Please ask for: Mrs D Johnson
Email: daun.johnson@arun.gov.uk
Telephone: 01903 737762
Our Ref: LU/136/21/PL
Your Ref:
Date: 19th May 2021

Application for Planning Permission

Development: Second & third storey extensions to existing care home to provide 14 No. new residential care rooms. This application may affect the setting of listed building, affects the character & appearance of the East Street Conservation Area & is in CIL Zone 4 (Zero Rated) as other development.

Location: Mewsbrook House 59 East Street Littlehampton BN17 6AU

DRAWN BY: EL
DATE: 3RD JUN 2021
DRAWING TITLE: EXISTING SECOND FLOOR PLAN
SCALE: 1:100 @ A1
DRAWING NO: E106

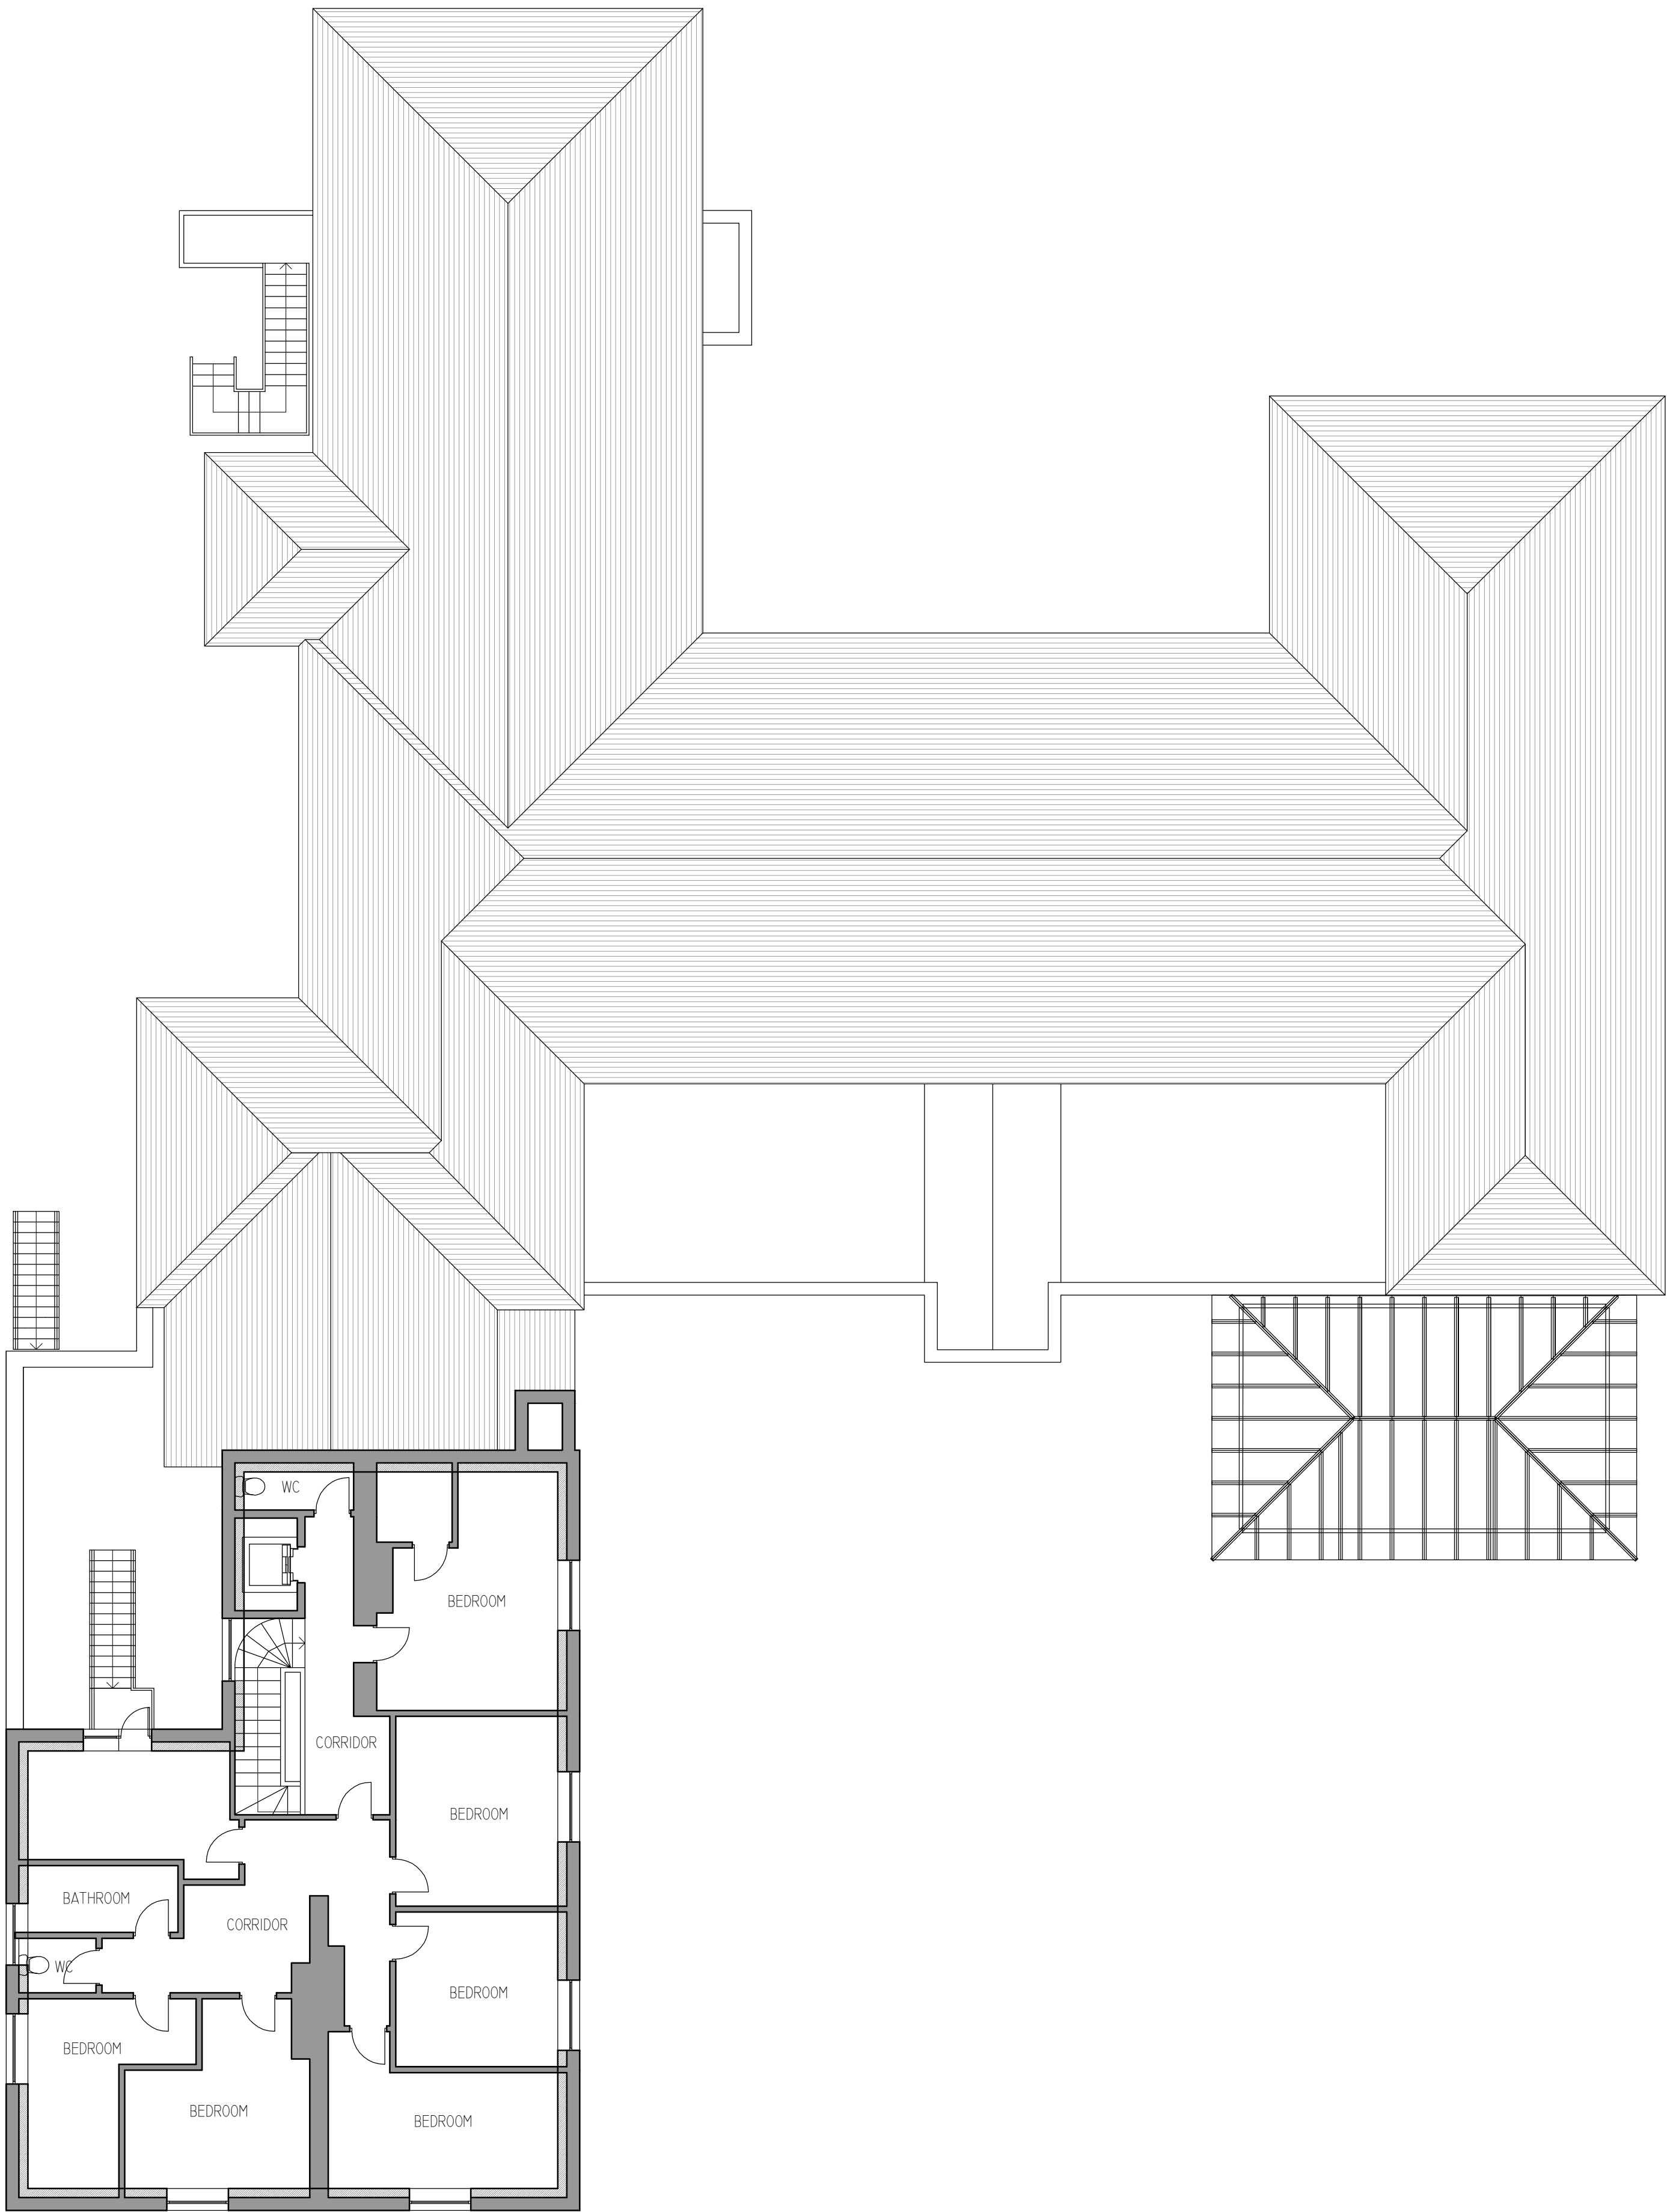
Please provide an existing second floor plan.
